Recommendation Report for Planning Permission for Works or Extension to a Dwelling

REF NO: AW/159/21/HH

LOCATION: 25 The Drive
Aldwick
PO21 4DU

PROPOSAL: Loft extension with 3 x rear dormers. This application affects the setting of the Craigwell House Conservation Area.

| Drawing number<br>AP/25/21/02 | Rev |

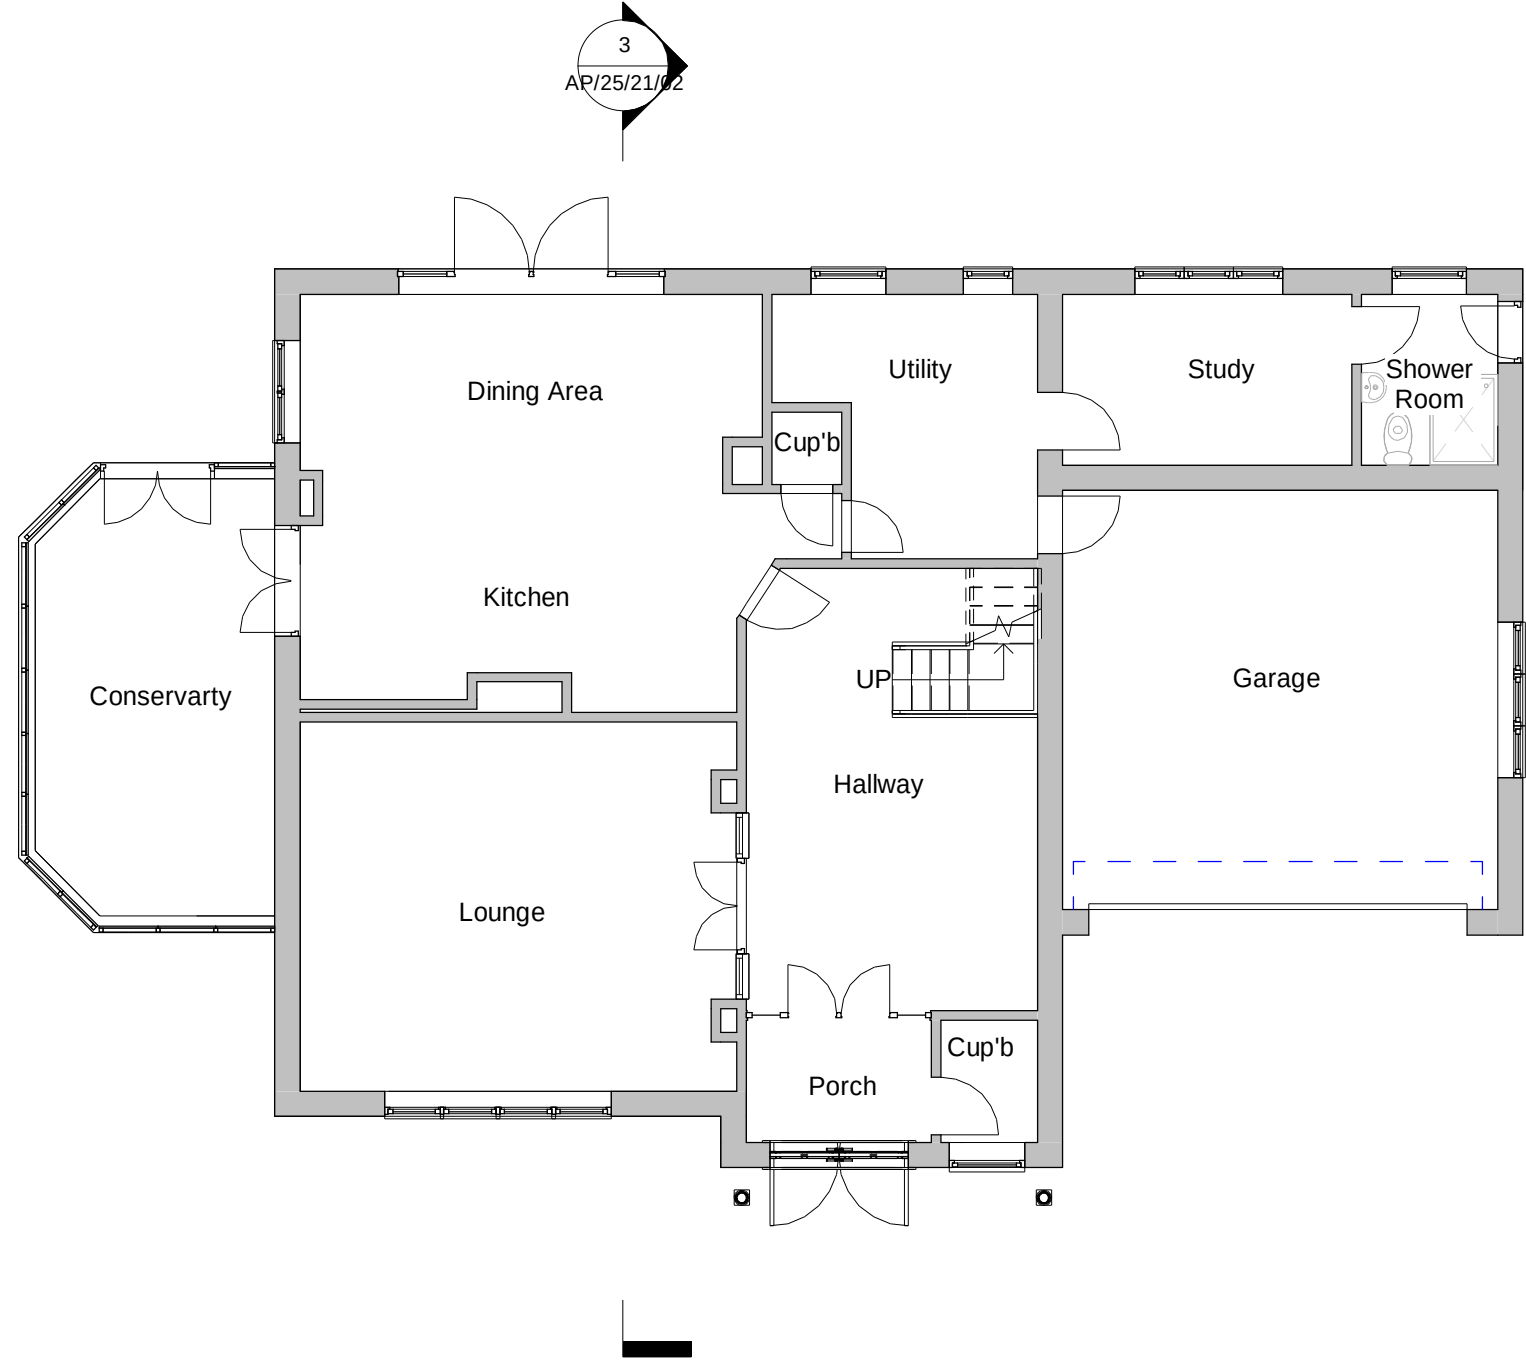
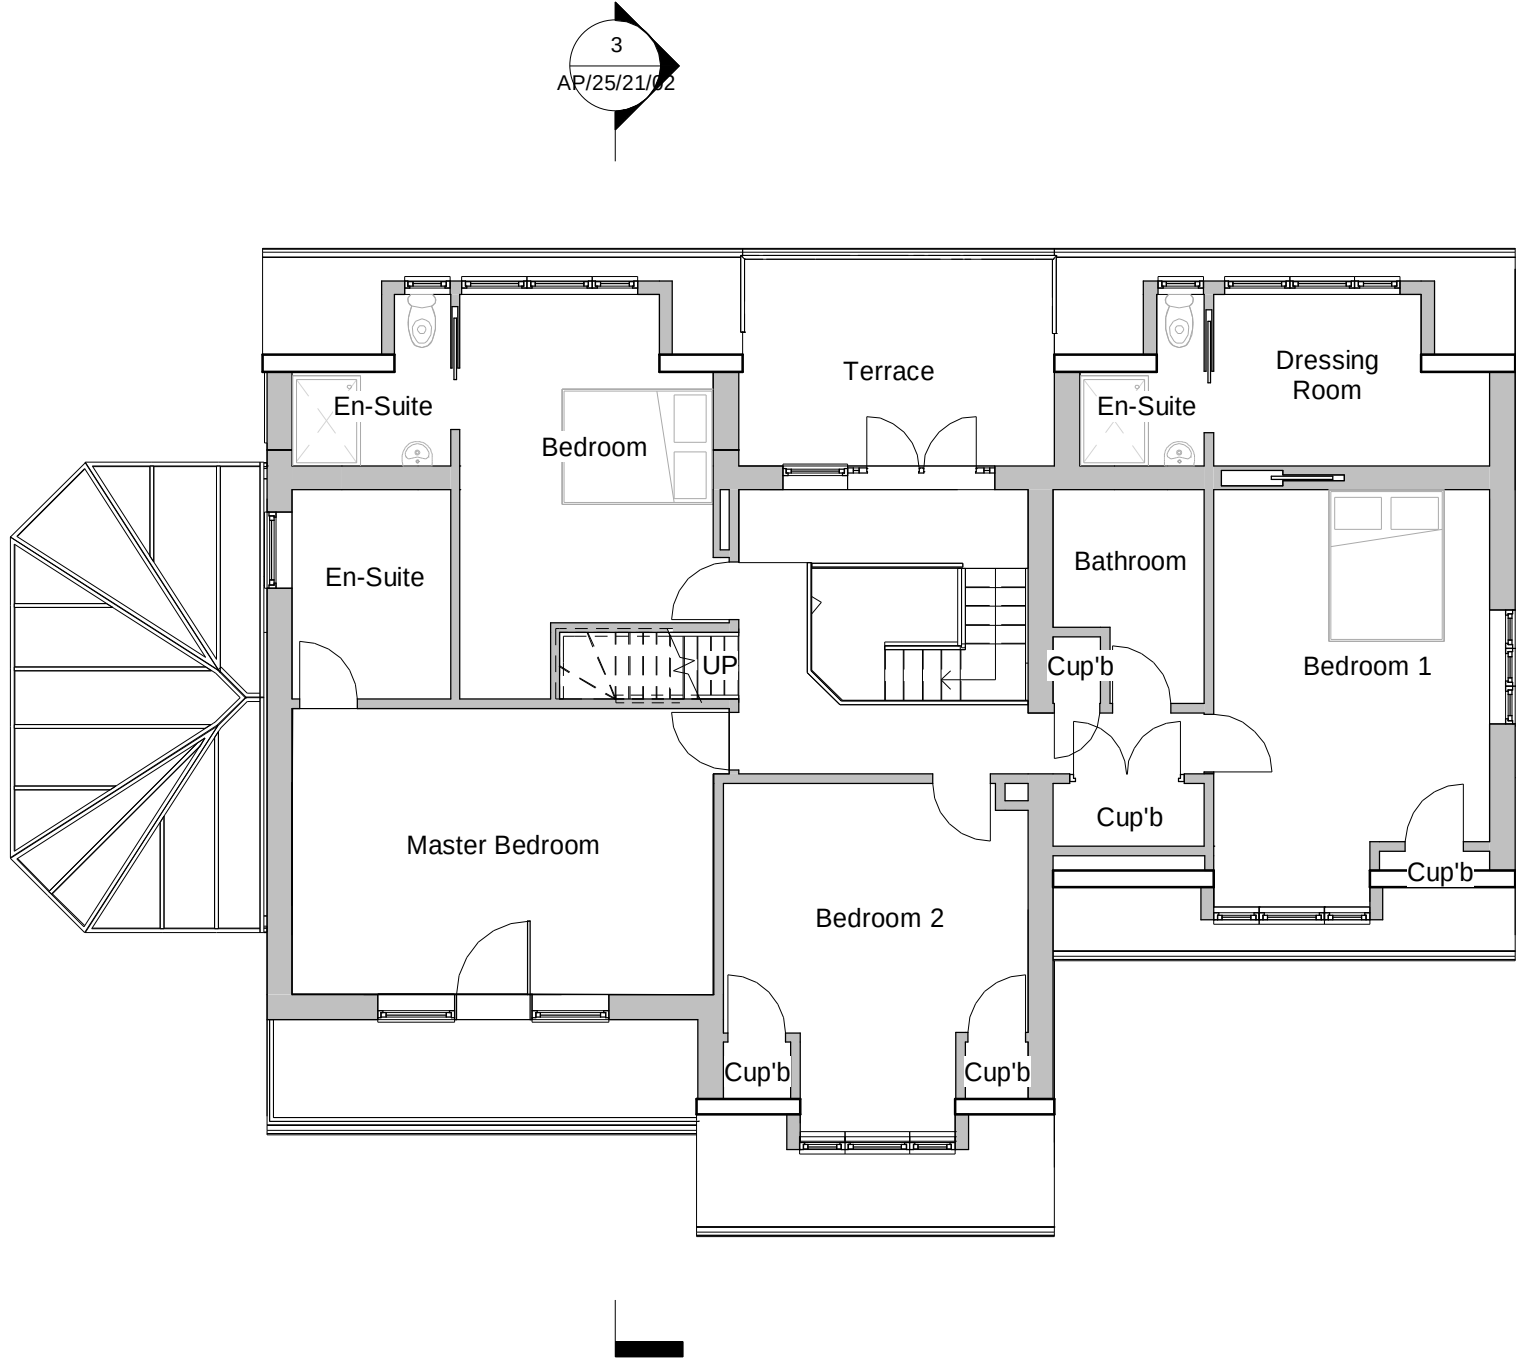
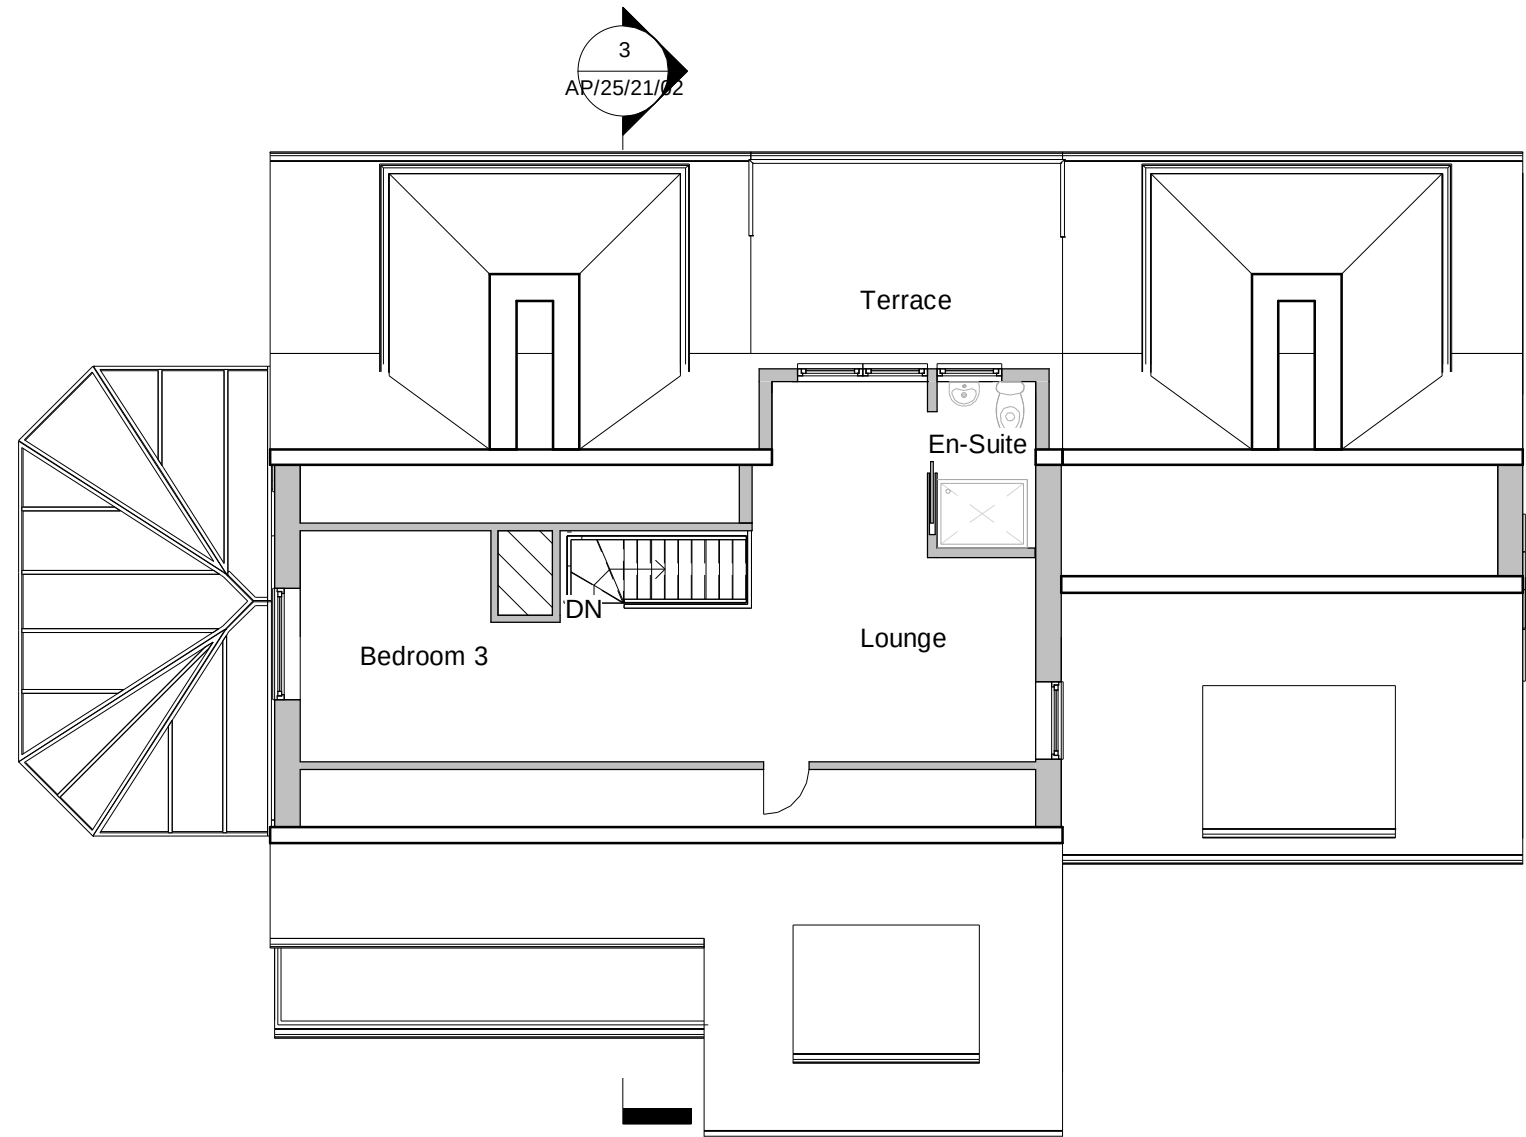
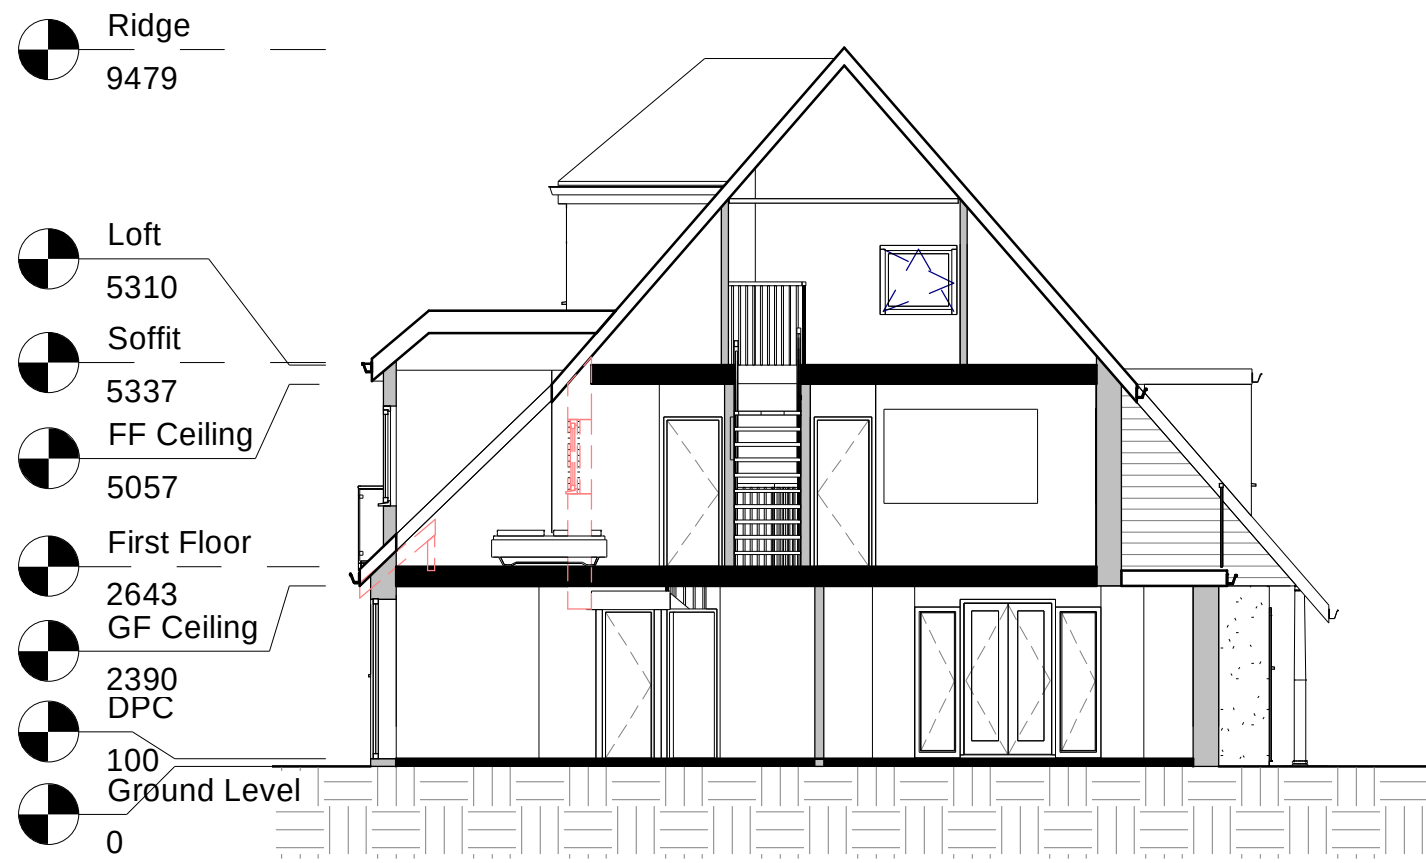
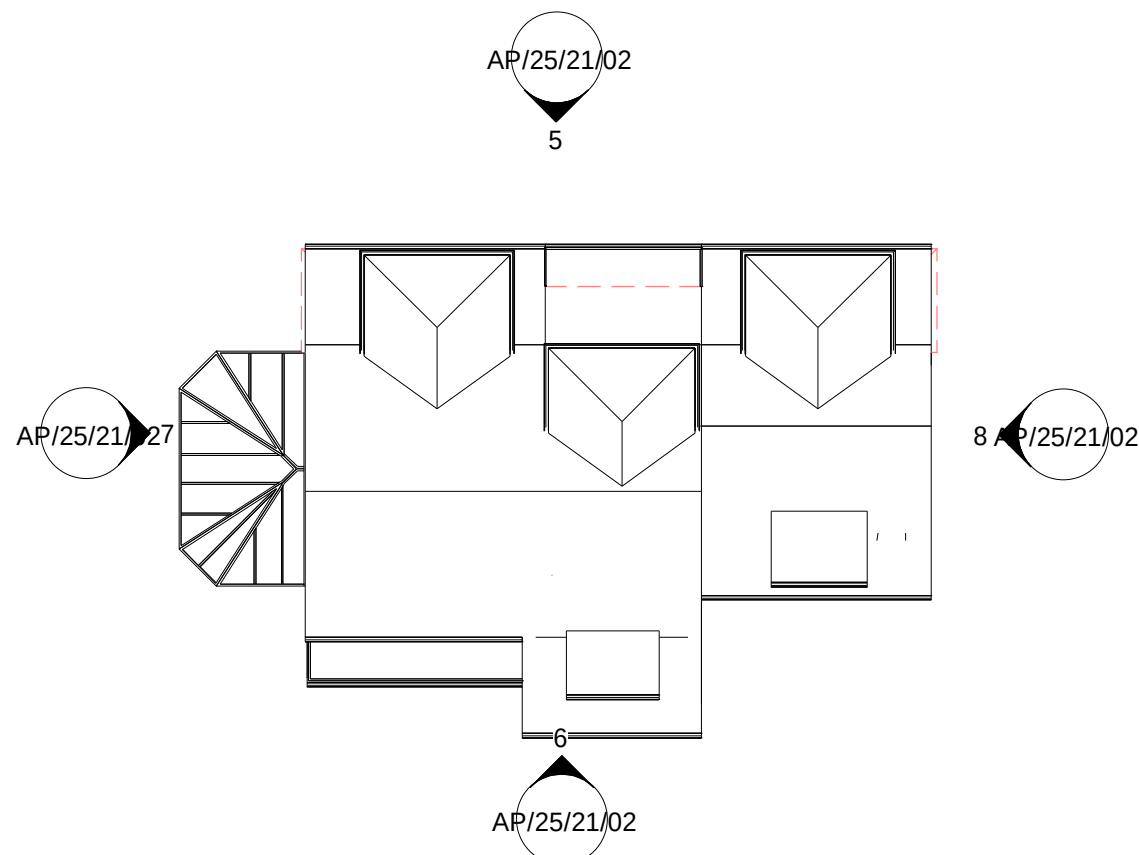
The dormers are large and pitch roof enhance the size of the dormer window. Class M of the design guide favours small dormers with a pitched roof and in this case the dormers are in keeping with requirements of the class M of the design guide, The dormers would not be visible from the public domain and therefore no harm to the host dwelling and settings of the conservation area is caused.

The rear dormer windows would not cause significant overlooking in the properties located at the rear of the northern elevation due to the 18m gap. An obscure glazing condition has been recommended for en-suite and dressing room windows. Overall the proposal is not considered to have detrimental impact on the amenities of the adjoining properties.

A small terrace is proposed - the roof acts as screening from the terrace. However a larger terrace is shown on plans and overlooking would be no worse from the small terrace than the existing one.

Reason: For the avoidance of doubt and in the interests of amenity and the environment in accordance with policy D DM1 of the Arun Local Plan.
- 3 The dormer windows to en-suite bathrooms/dressing room shall be at all times be and remain glazed entirely with obscure glass.
